**SSD22191322 MOD 1, OAKDALE WEST STAGE – S.4.55(1) APPLICATION TO REMOVE
CONDITION B28**

This is the **first (1)** modification to SSD22191322 and seeks to:

- 1) update the warehouse 4E façade** to align with Goodman's recent design protocol update
- 2) remove Condition B28** from the consent on the basis it is inappropriate and unnecessary due to the fact no storage of dangerous goods over the SEPP33 threshold levels is proposed at the site

1 ELEVATION NORTH - WAREHOUSE 1 : 500

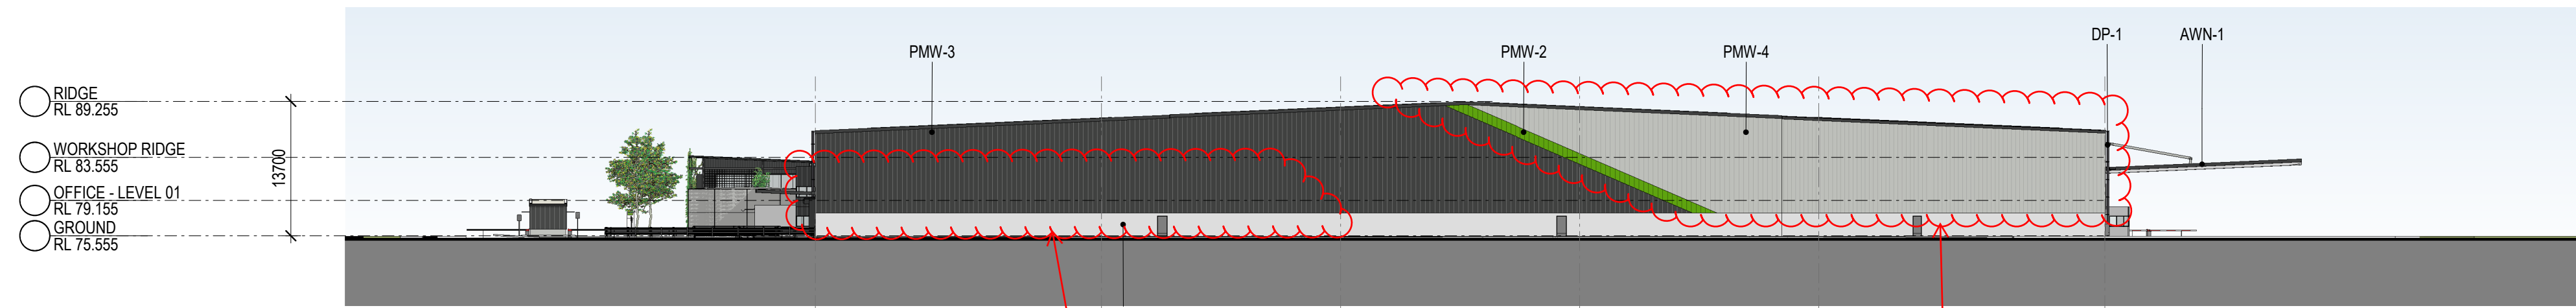
A) North Elevation:

- Green stripe removed and dark 'monument' colour replaced with 'shale grey'
- Tenant sign and Goodman lightbox signage locations switched
- Office number changed from '4E' to '6'

Remove green stripe and change warehouse colour to colorbond shale grey

Change number from 4E to 6

2 ELEVATION SOUTH - WAREHOUSE 1 : 500

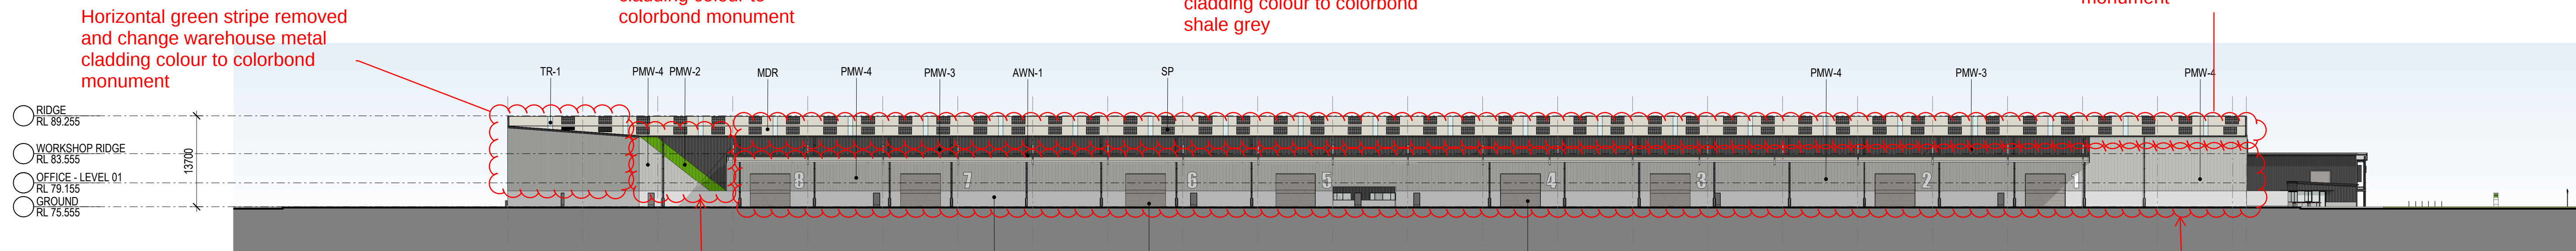
B) South Elevation

- Green stripe updated and change from metal cladding colour to 'monument'.
- 'Shale grey' colour component added

Remove green stripe and change warehouse metal cladding colour to colorbond monument

Revised green stripe and change warehouse metal cladding colour to colorbond shale grey

3 ELEVATION EAST - WAREHOUSE 1 : 500

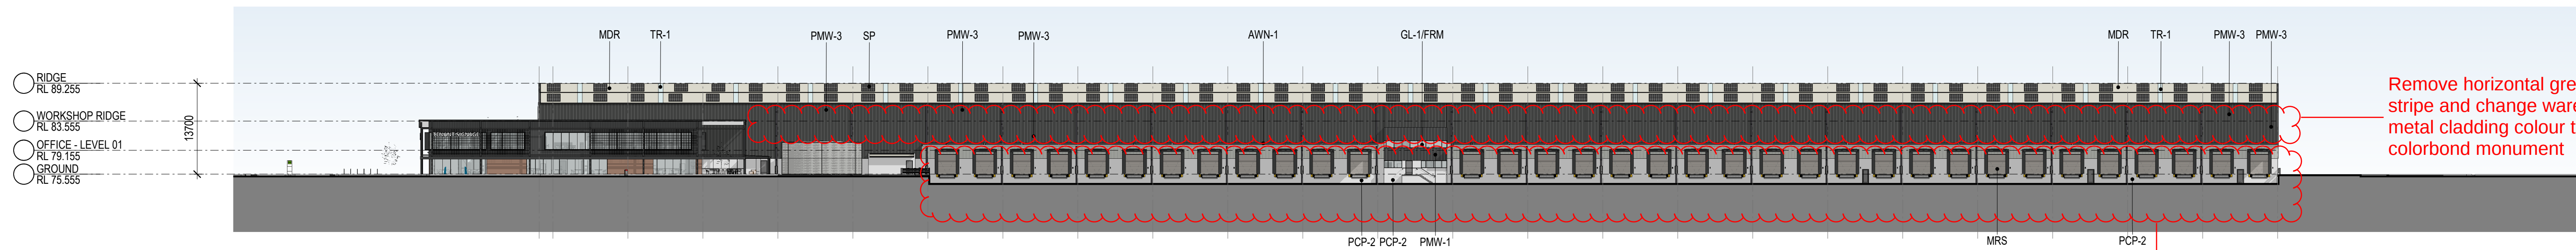
C) East Elevation

- Horizontal green stripe removed and update to metal cladding to colourbond 'monument'
- Addition of diagonal green stripe to mirror that included on north and south elevation
